**CHENNAI METROPOLITAN DEVELOPMENT AUTHORITY**

**Letter No. CMDA/PP/MSB/N/0803/2019**

Sub: CMDA – APU – MSB(North) – Planning Permission Application is for the construction of Basement floor + Stilt cum Ground floor + 8 floors + 9th floor (Part) – Residential Building with 152 Dwelling units, Retails shop in Stilt & 1<sup>st</sup> Floor, Multipurpose Hall, Gym, Indoor Games, Home theatre in 1st floor at Old Survey No. **200/2A2A** (part) & 2B, Ward No. J, T.S. No. **82/2** & 89 of **Thiruvottriyur Village**, Ennore Expressway, Thiruvottriyur Taluk, Chennai applied by **(1) M/s.Provincial Investment Corporation (P) Ltd** Represented by N.Sivakumar and **(2) Ms.Prakirti Agarwal**- Forwarded to Govt. for approval – Reg.

SECTION 1 - 1

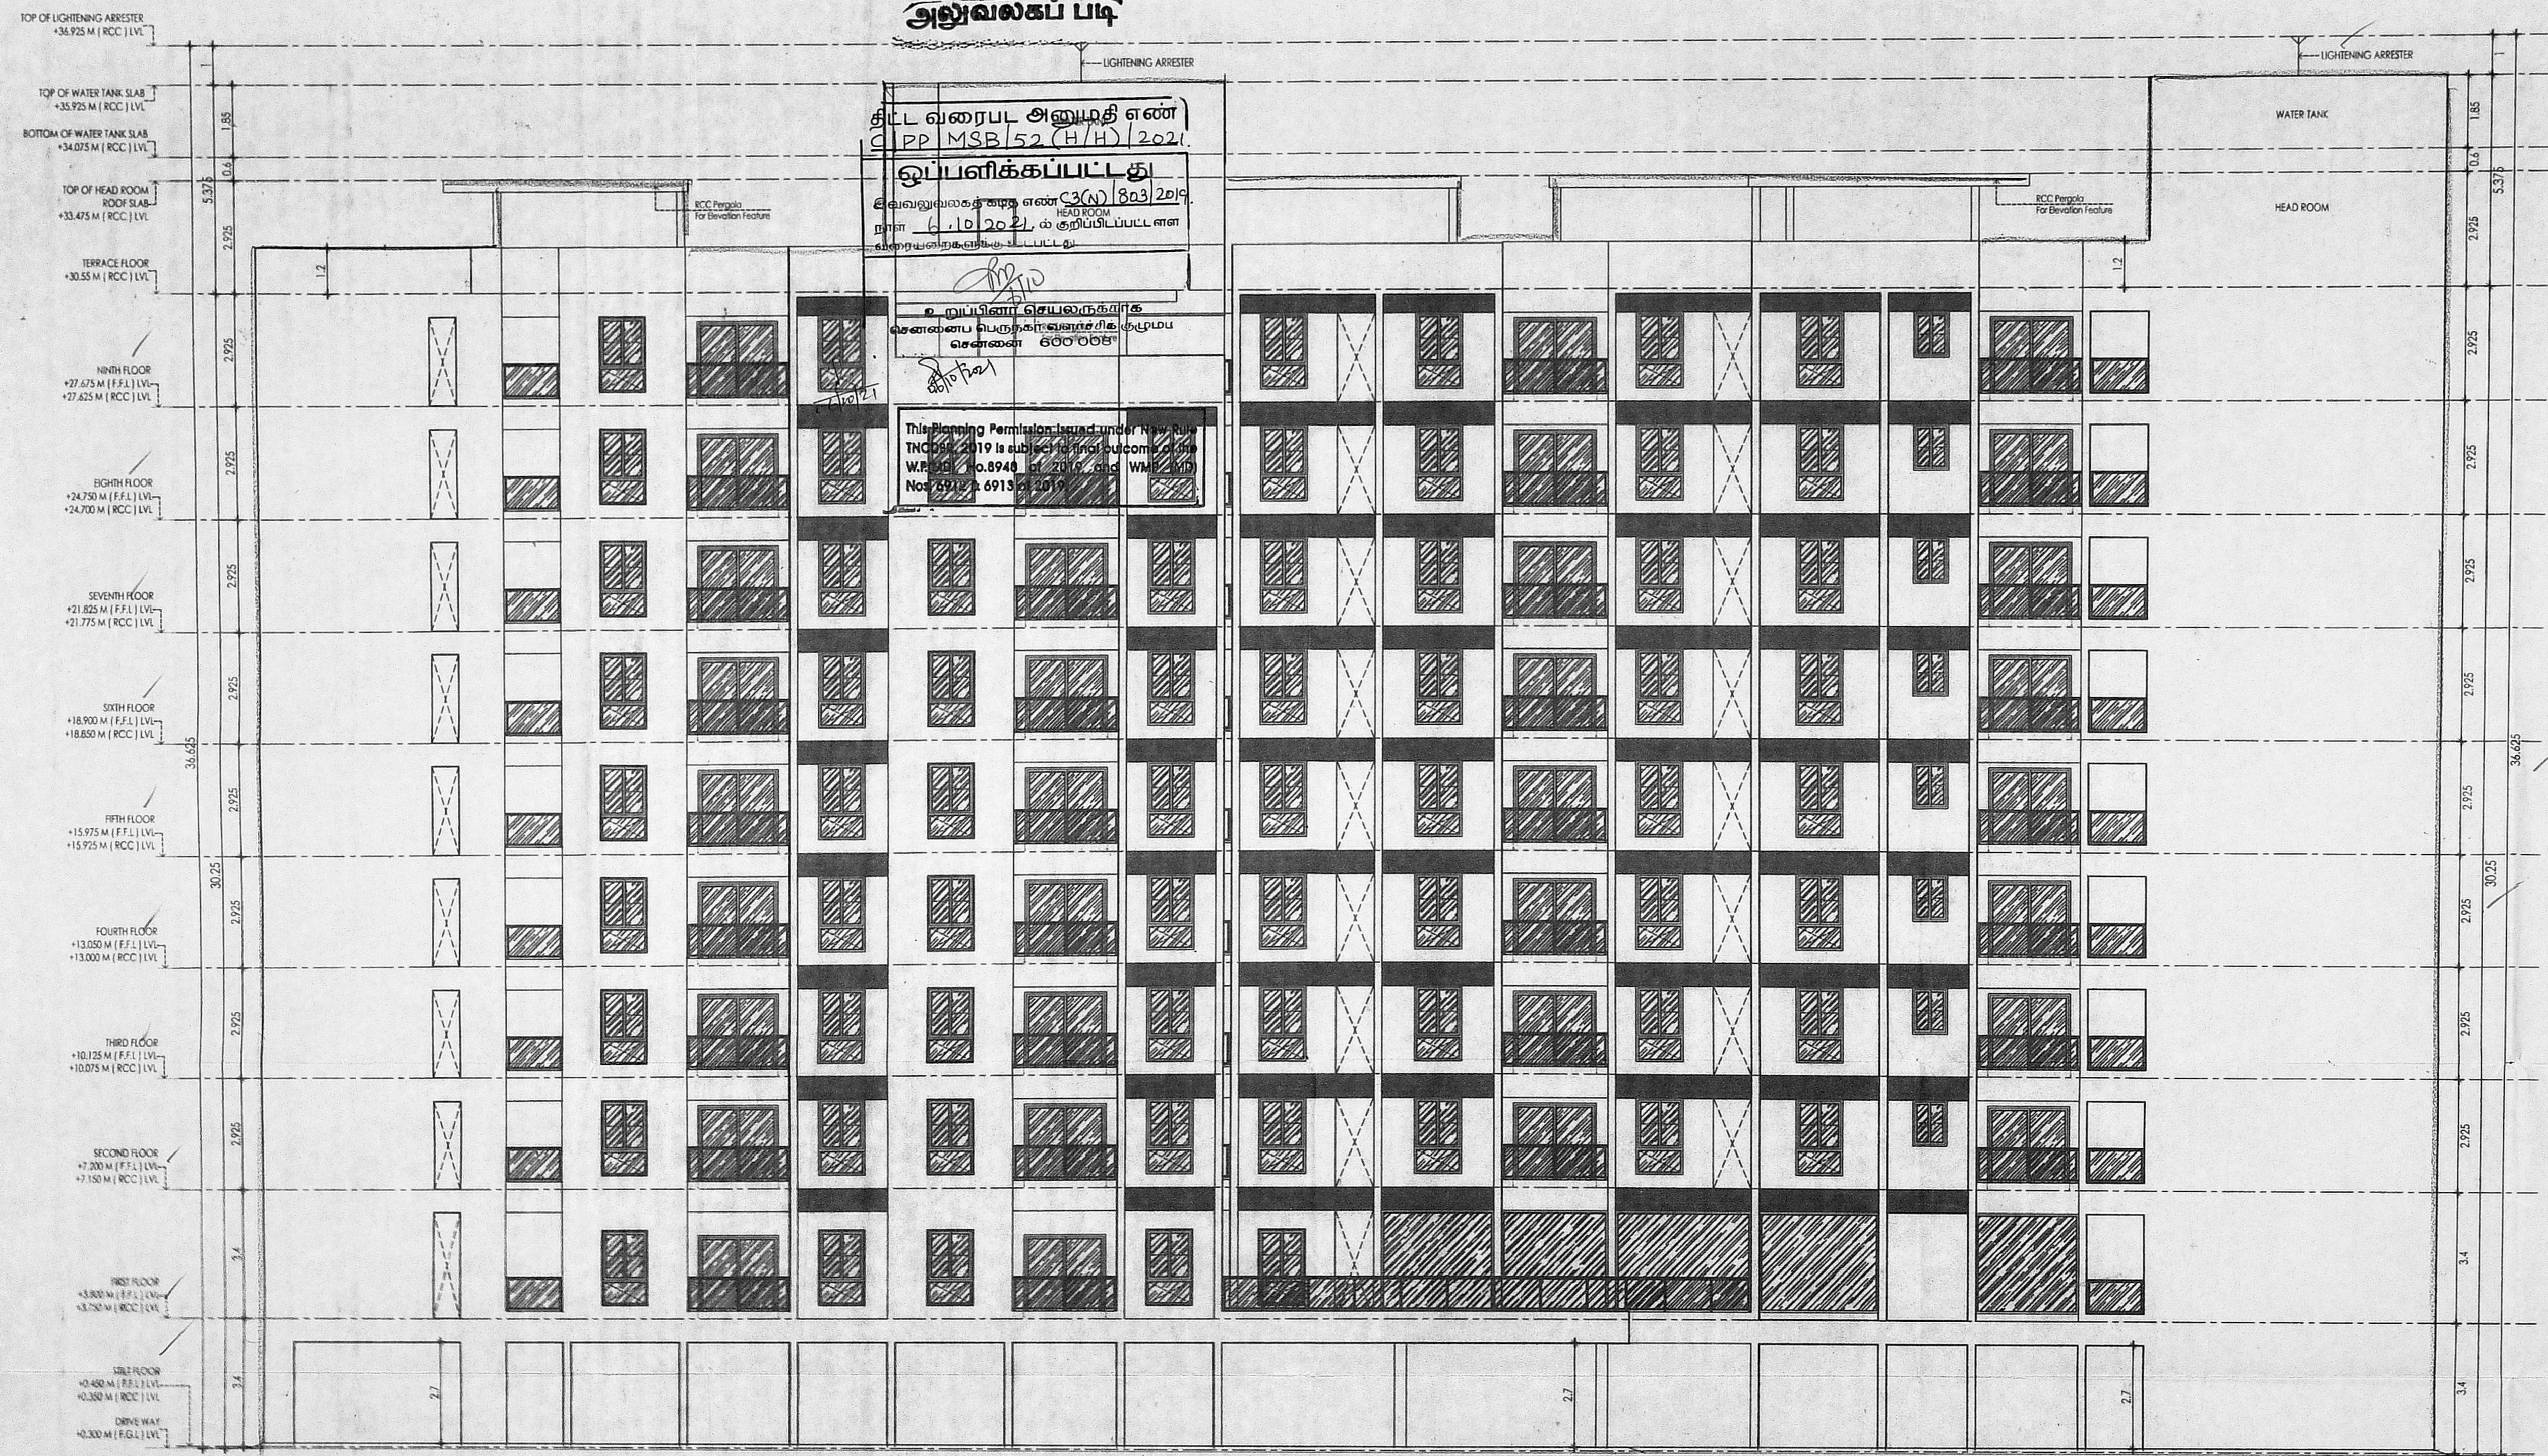
- (vii) Open DG set in the setback space is not permissible and the same need to be removed and relocated.
  - (viii) Section & Elevation requires correction with respect to individual floor plans.

- (ix) Section passing through Pergola in Terrace level to be shown.
  - (x) Gazebo shown in 1<sup>st</sup> floor plant to be removed.
  - (xi) Title & Area Statement requires correction.
